EXAMINING AUTHORITY FOR THE DROVES SOLAR FARM (EN0110013)

SUBMISSION FOR DEADLINE 2 (19 JUNE 2026)

DOCUMENT: Written Representation by a member of Castle Acre Parish Council. [REDACTED]

Chapter 8: Cultural Heritage and Archaeology Prepared by: GHC Heritage Date: November 2025 PINS reference: EN0110013 Document reference: APP/6.2 (Original) APFP Regulation Reg 5(2)(a) Planning Act 2008 Infrastructure Planning (Applications: Prescribed Forms and Procedure) Regulations 2009.

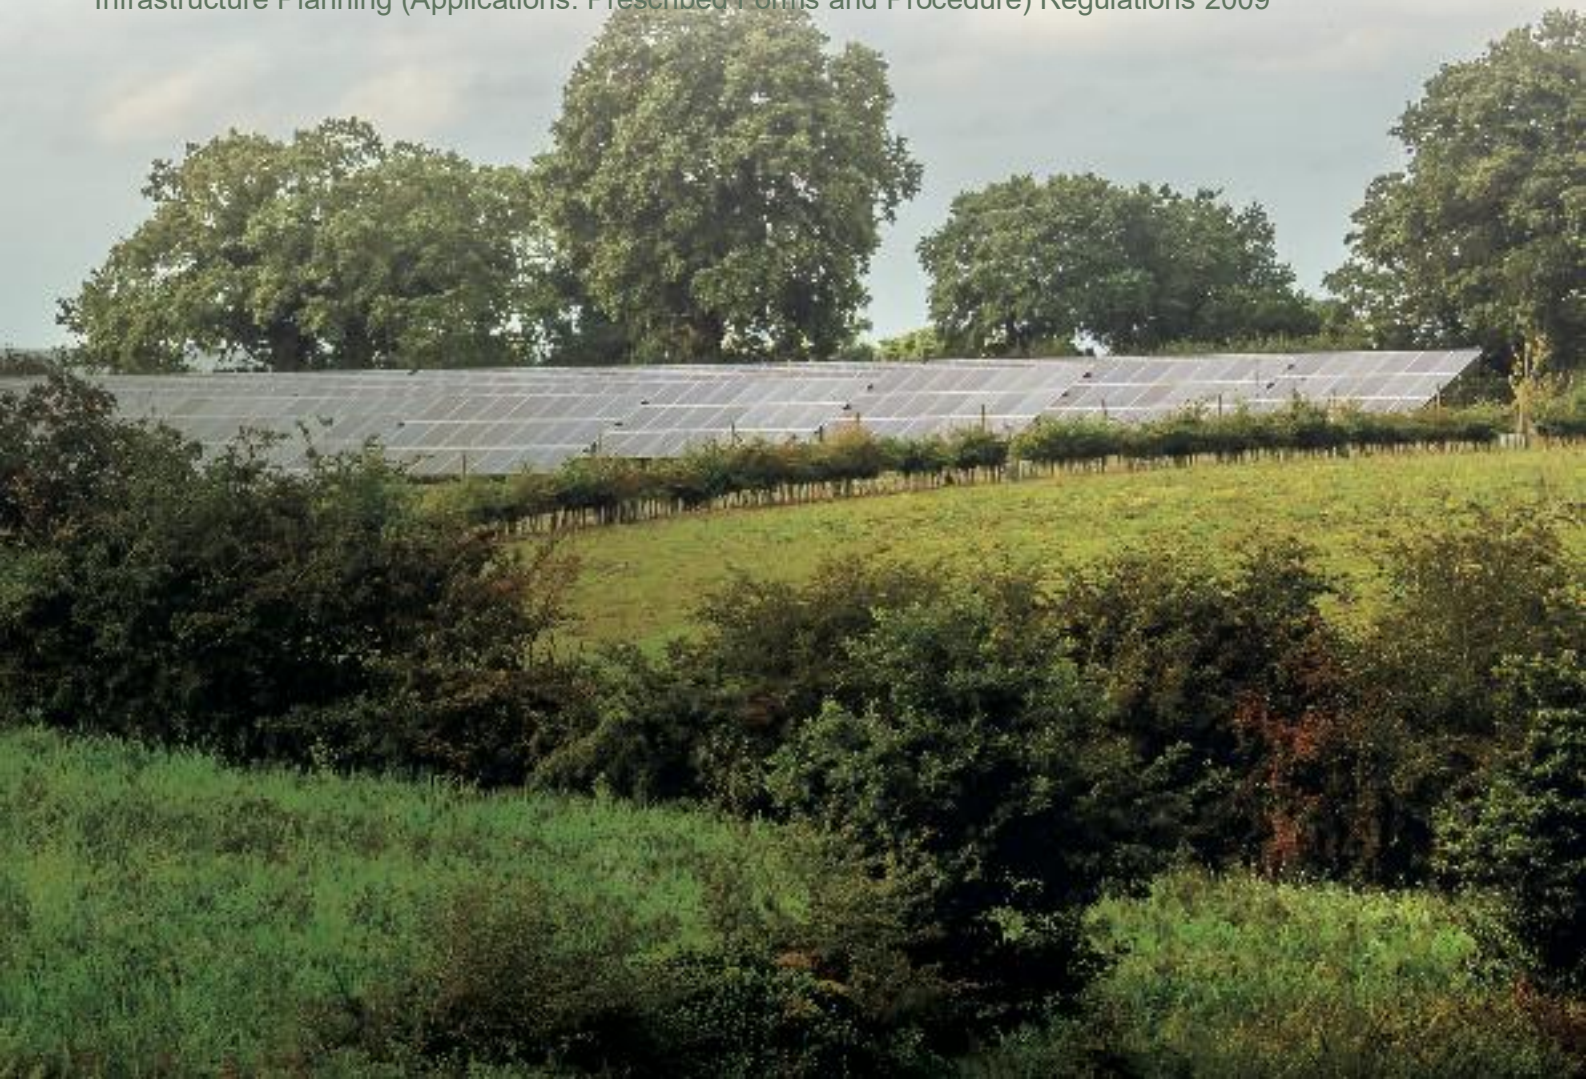
The proposed new pylons will be highly visible from Castle Acre Priory, especially as they punctuate the skyline. Whilst there are already pylons visible in these views, under Scenario A the combined effect of both existing and new pylons will increase their prominence in the landscape, but not to a degree that they may draw the observers eye away from elements that add to the appreciation of the priory's significance.

AM Where is the evidence for public consultation that the impact from the solar arrays and the new pylons would be 'negligible' ?

DRAWING TITLE
 ES Figure 6.15 Viewpoint 14 - Castle Acre Castle, Cuckstool Lane, Castle Acre
 REVISION P1, Text update DRN JB CHK OWh/MB APP RP
 DWG NO 9485_0525 DATE 06/01/2026 Sheet 1 of 3

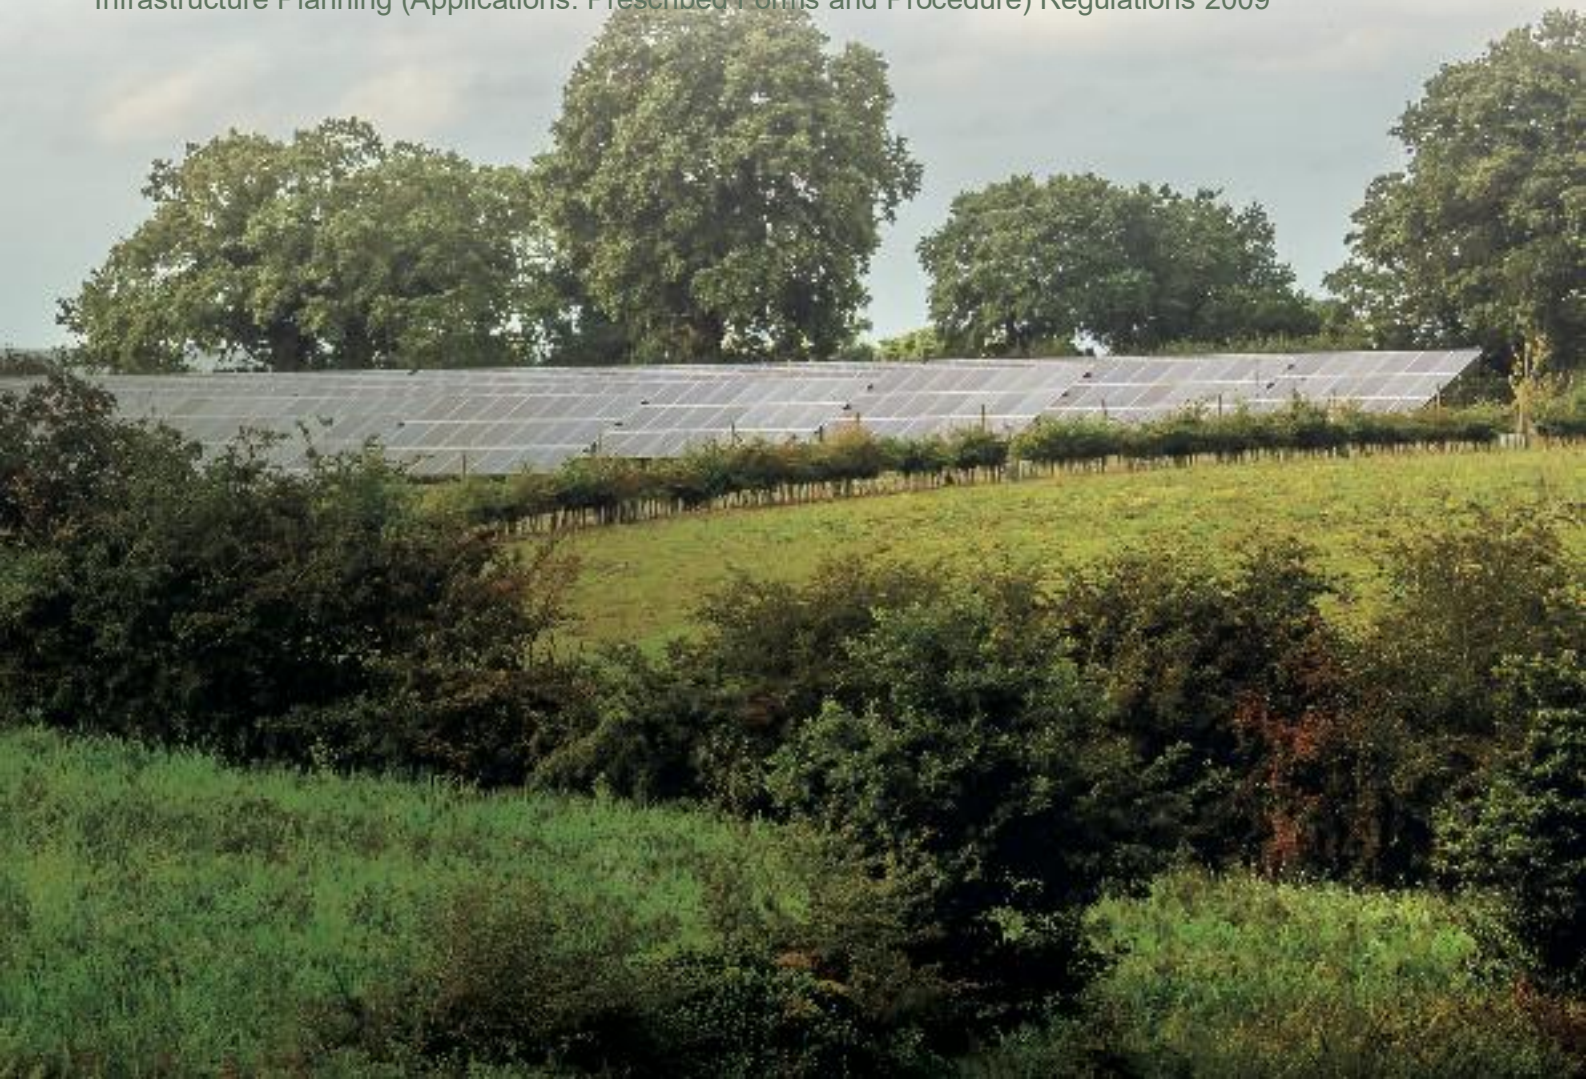
AM If, as stated, the 'majority' of the views will be unchanged, there is a minority that will be adversely affected and detract from 'the wider vista'. Such intrusion could be reason enough to refuse planning permission.
